THE RESERVE AT MISHAWAKA
FIR ROAD AT THE INDIANA TOLL ROAD
MISHAWAKA, IN
CONSTRUCTION DETAILS
ISSUE FOR BID

SHEET NO.
L-4.4
CONSTRUCTION DETAILS

Sign Plan_V1.pdf Markup Summary

1
L3.4 MAIN MONUMENT SIGN - FRONT ELEVATION

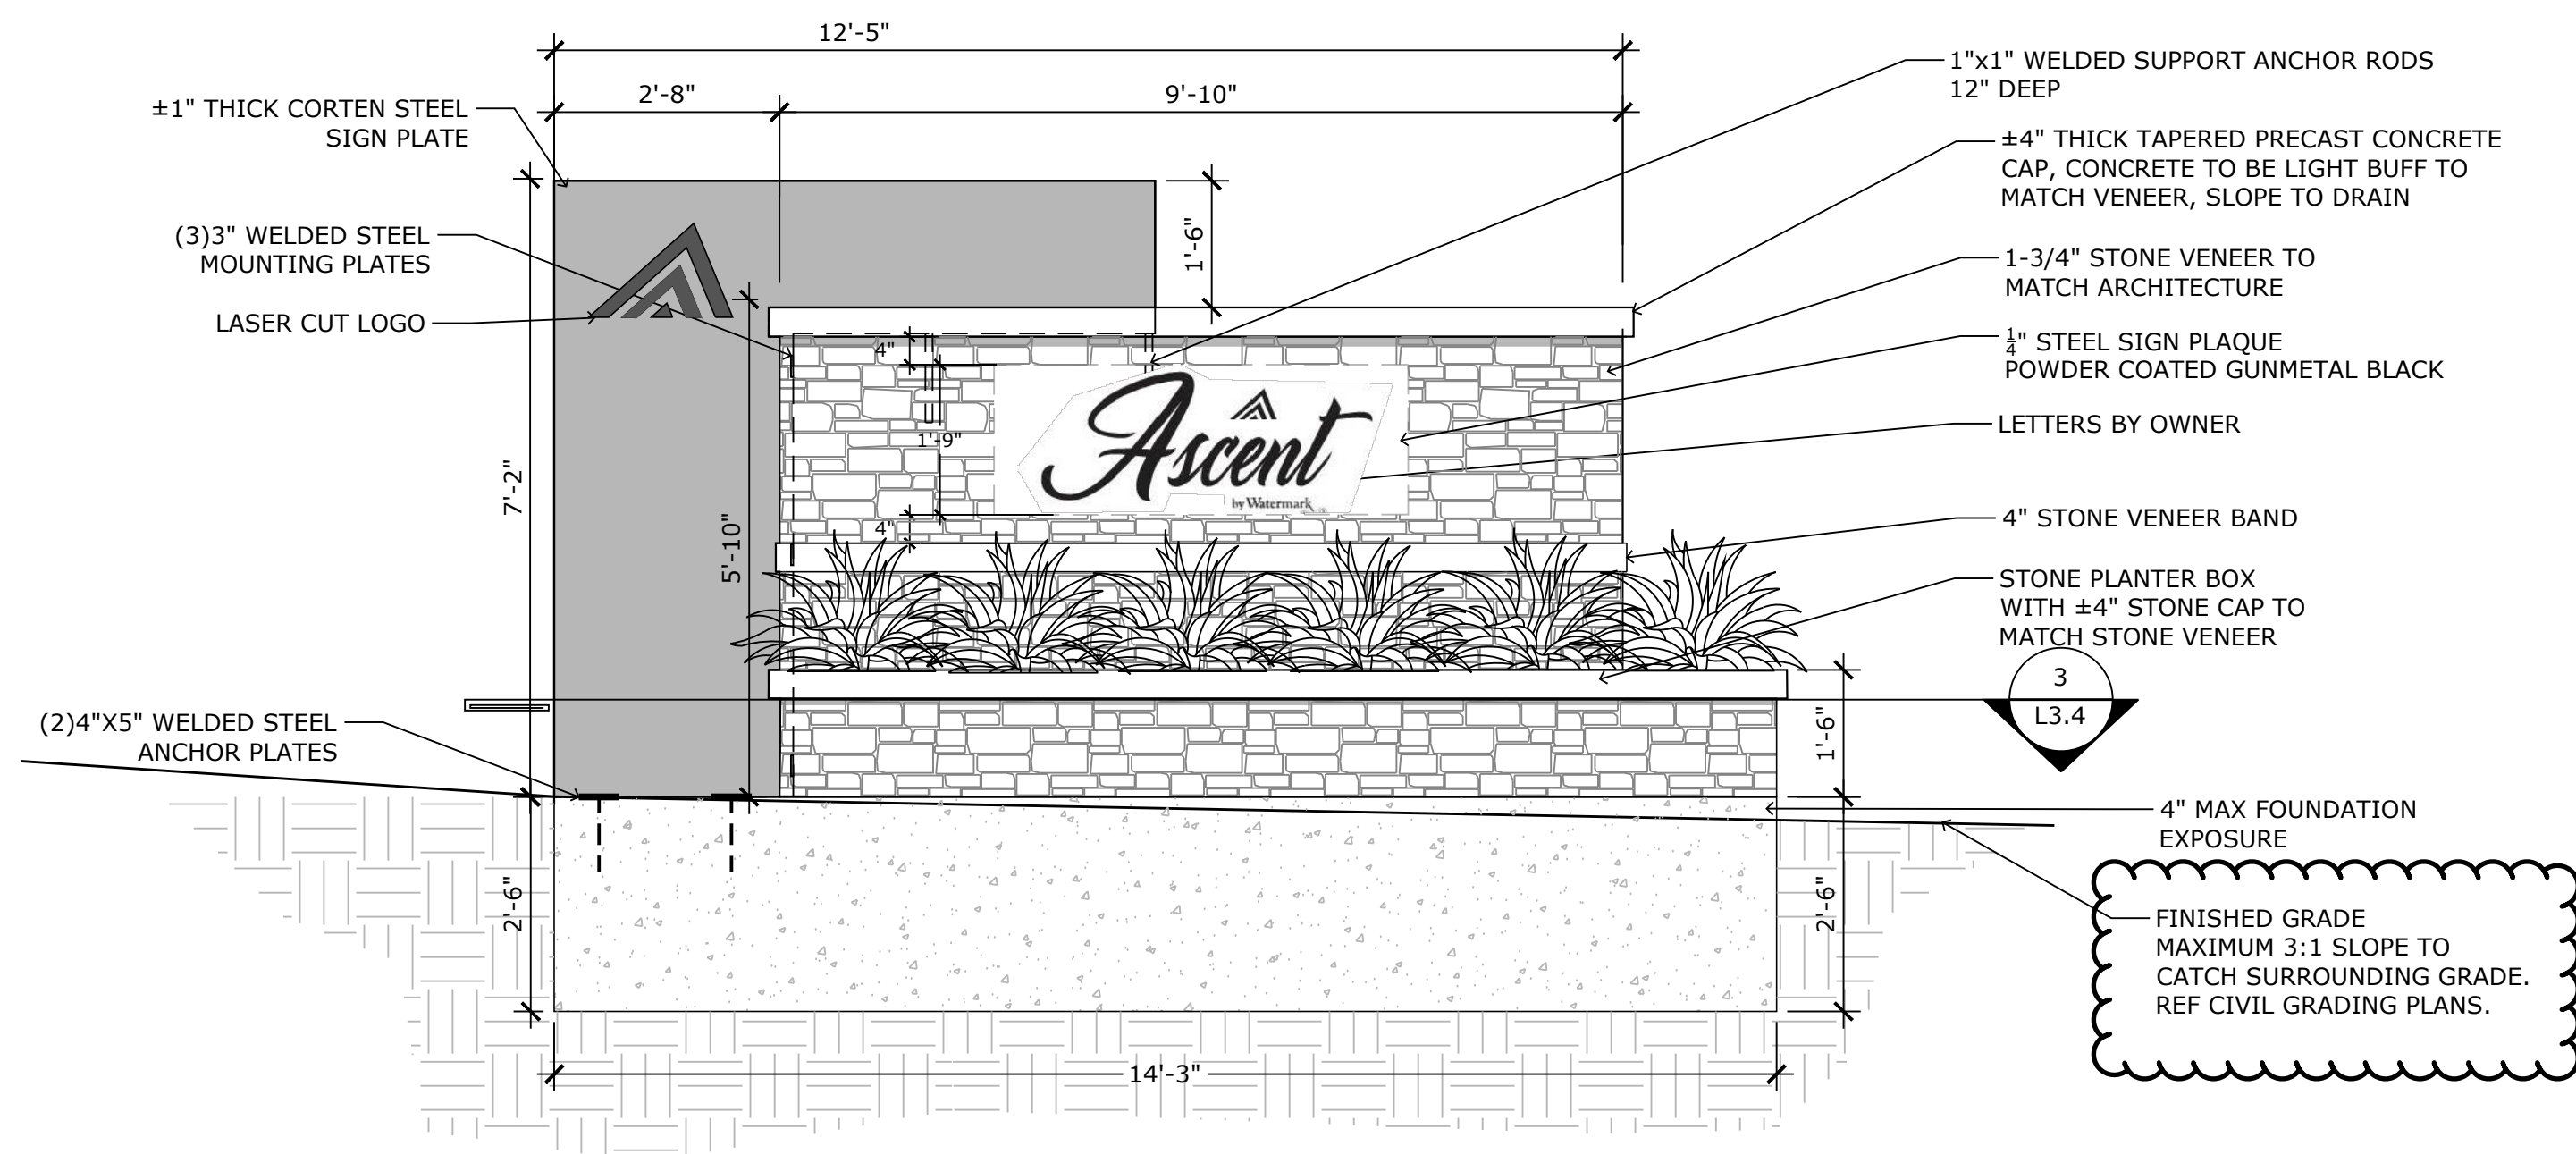
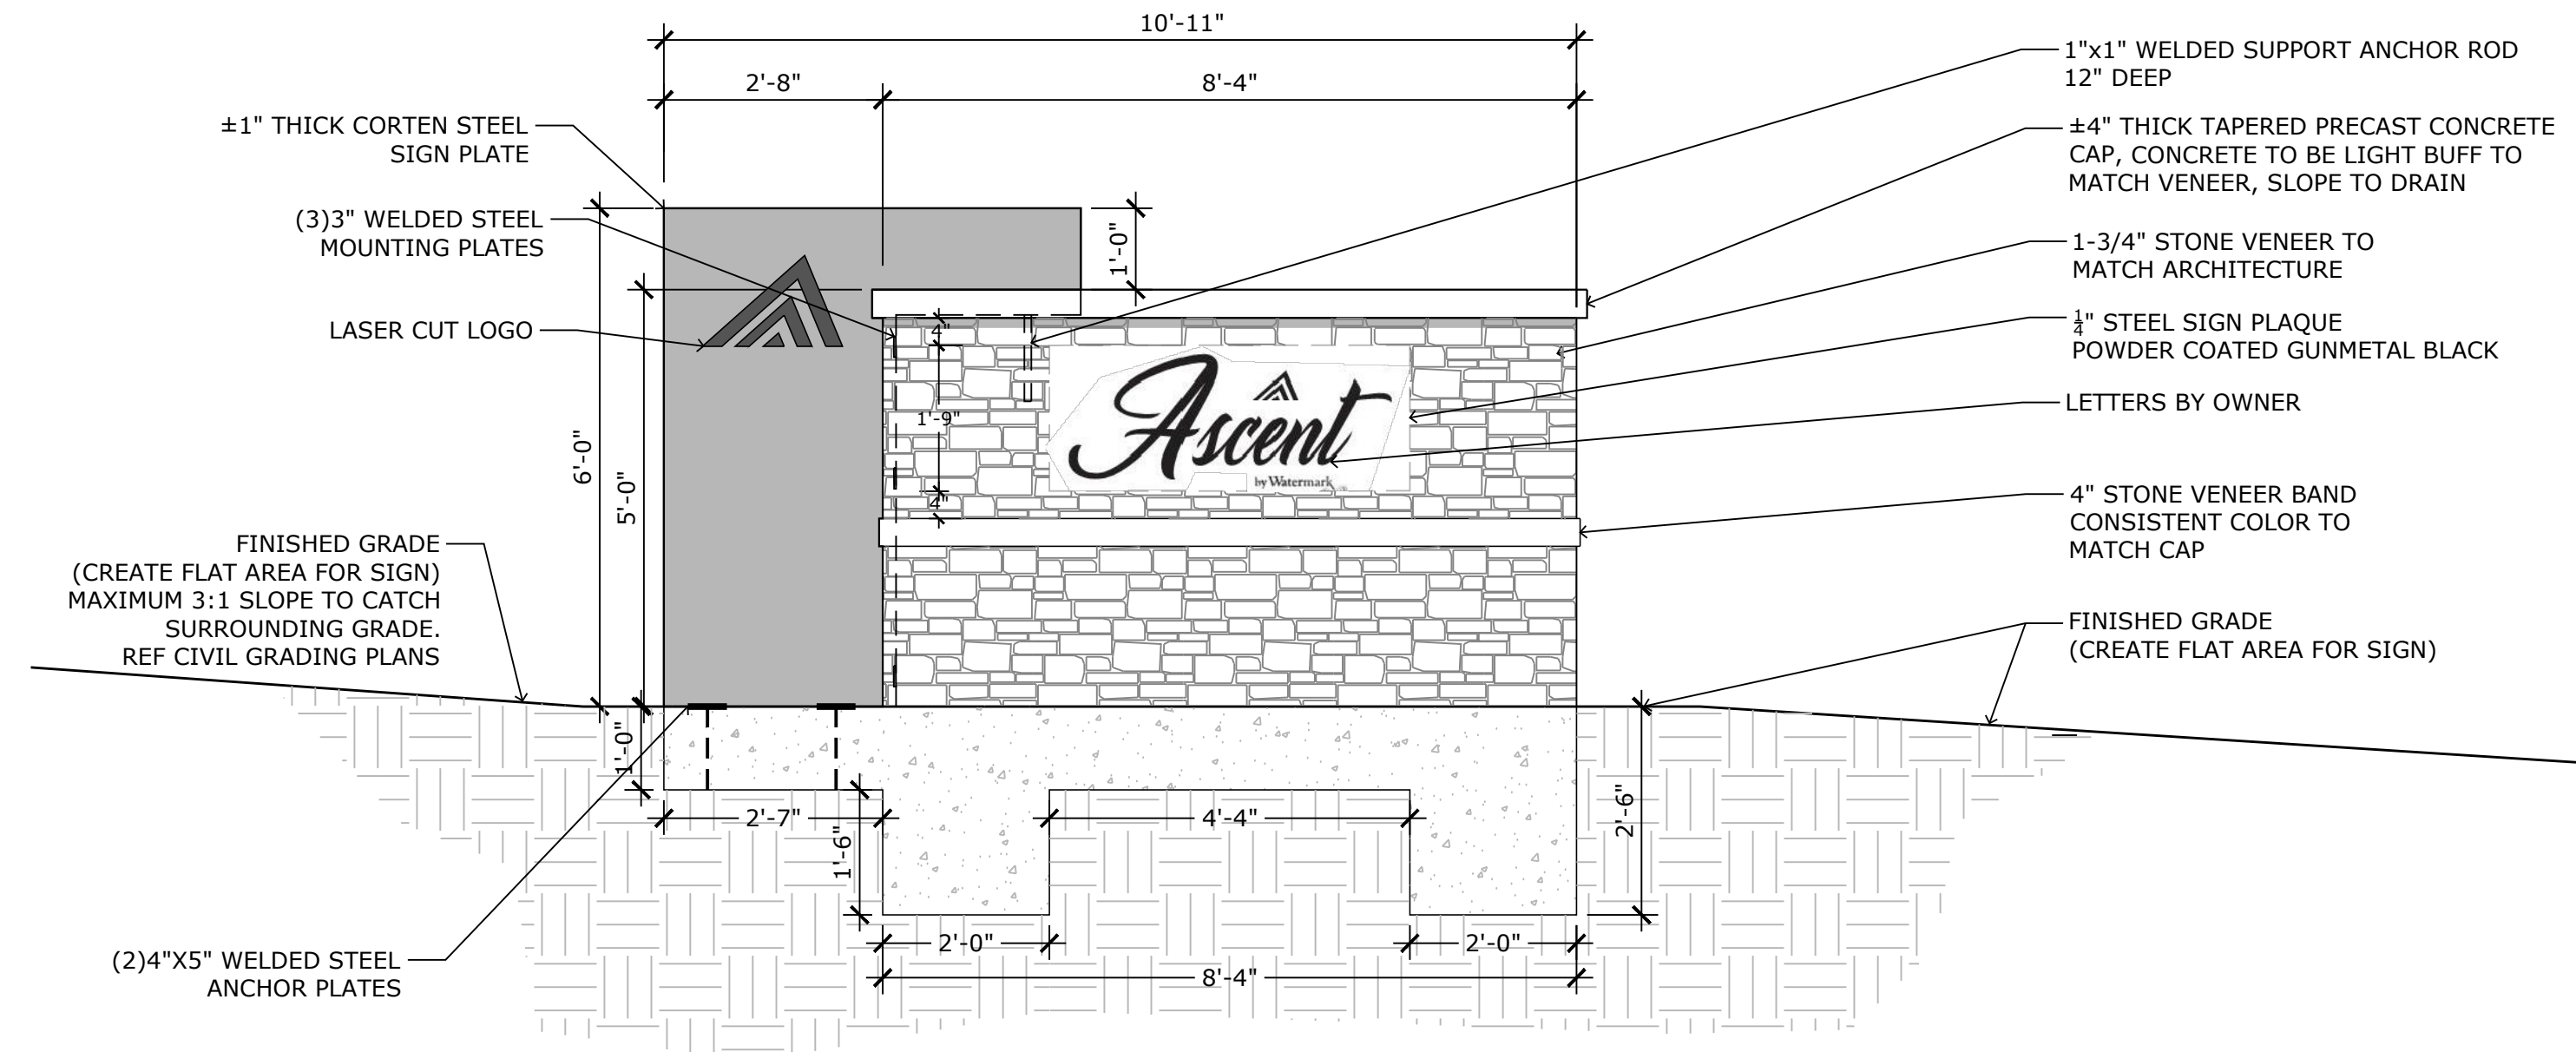
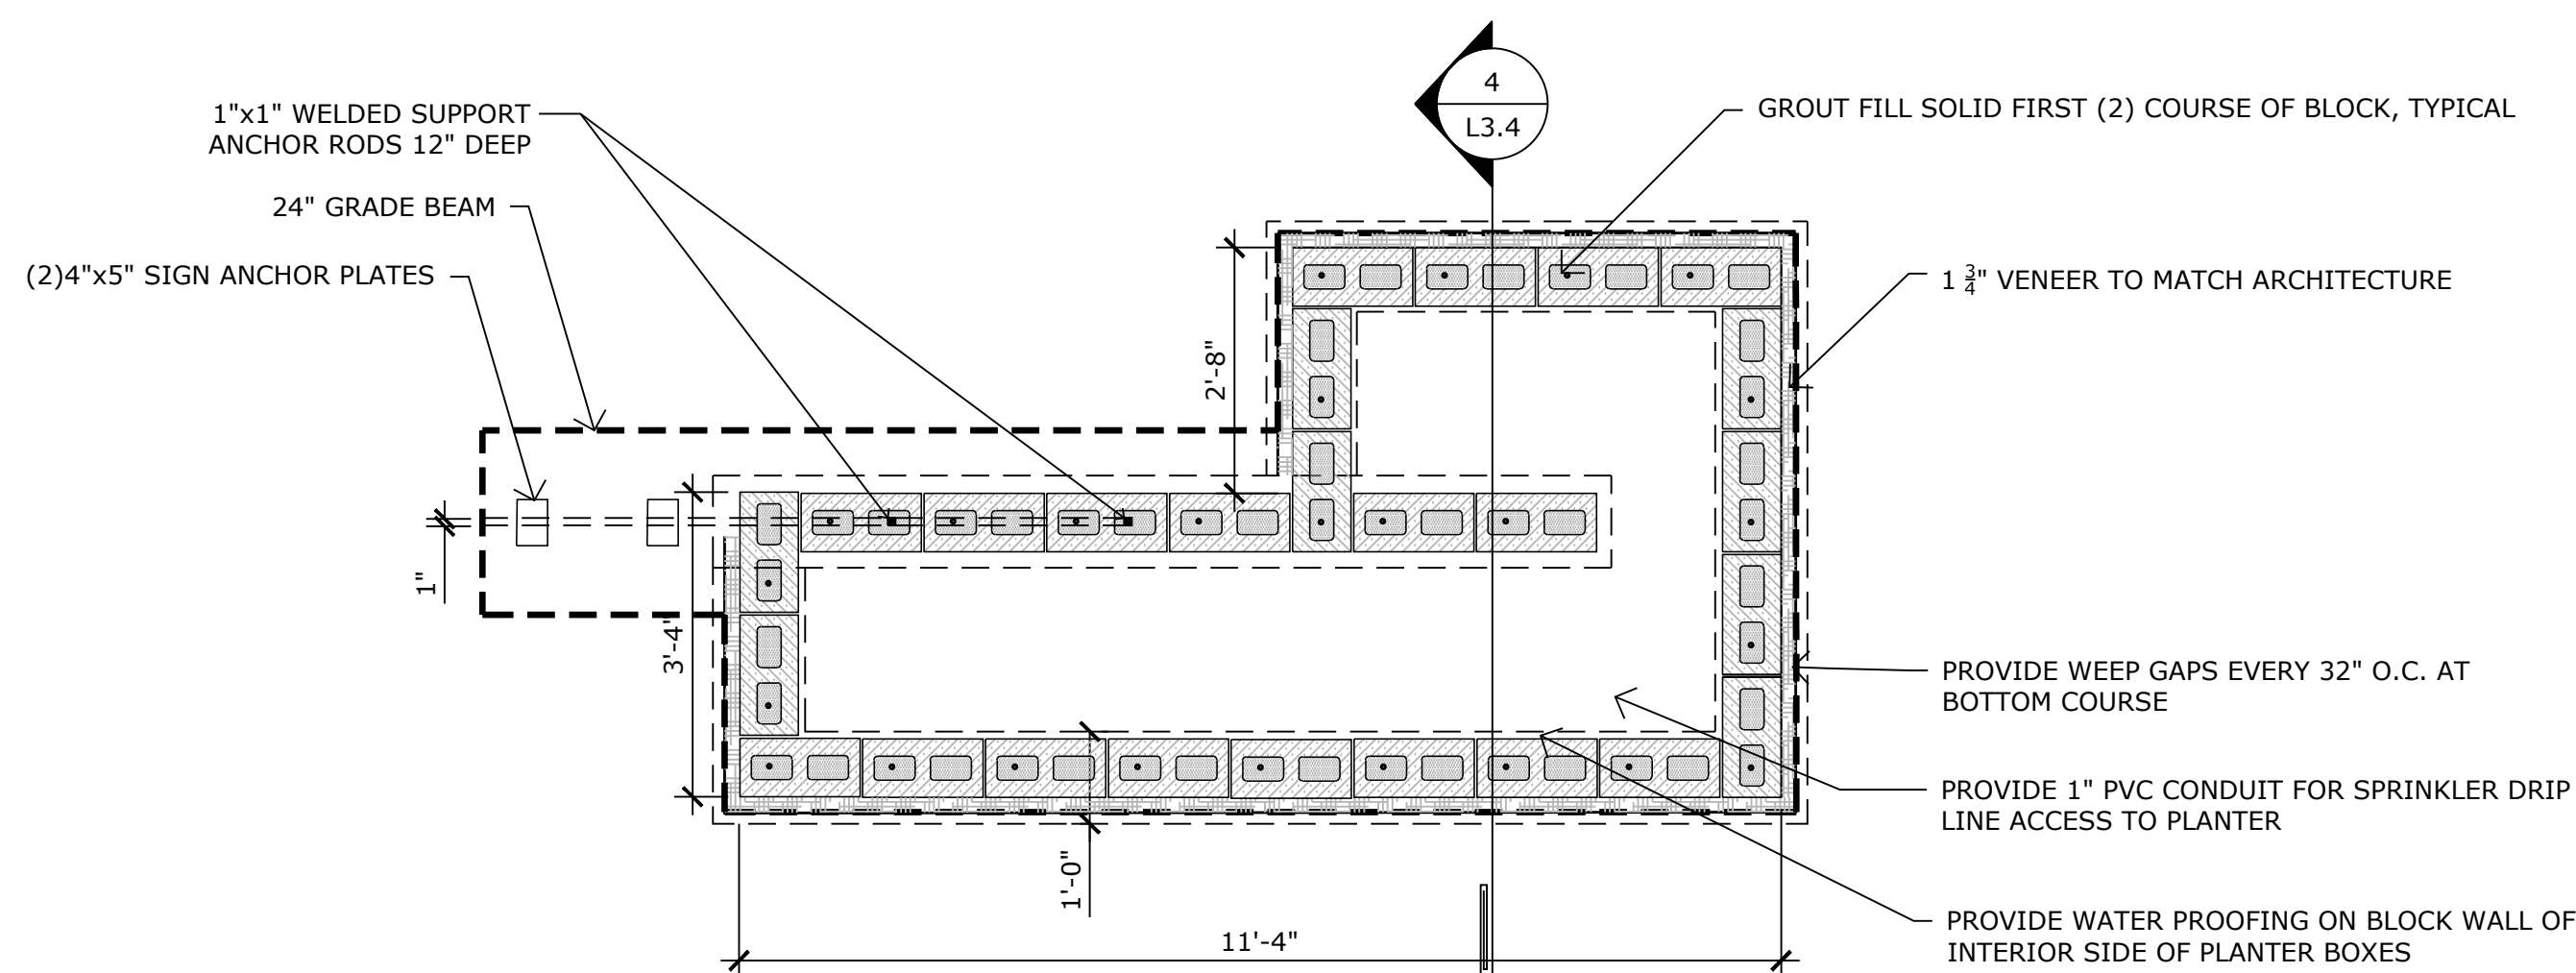
Per Ch. 6 Signage Standards: identification signs in residential zoning districts cannot exceed 6 feet in height and 40 square feet in area. They must also be located at least 25 feet from all lot lines adjacent to public and private ROWs or easements.

Proposed signage locations and quantity are not shown / clear - I see two monument sign called out on the landscape plan sheets. Please identify hereon how many signs are proposed (is there only one sign proposed at one entry point?) and identify (description is OK rather than depiction) of each of the proposed signage locations.
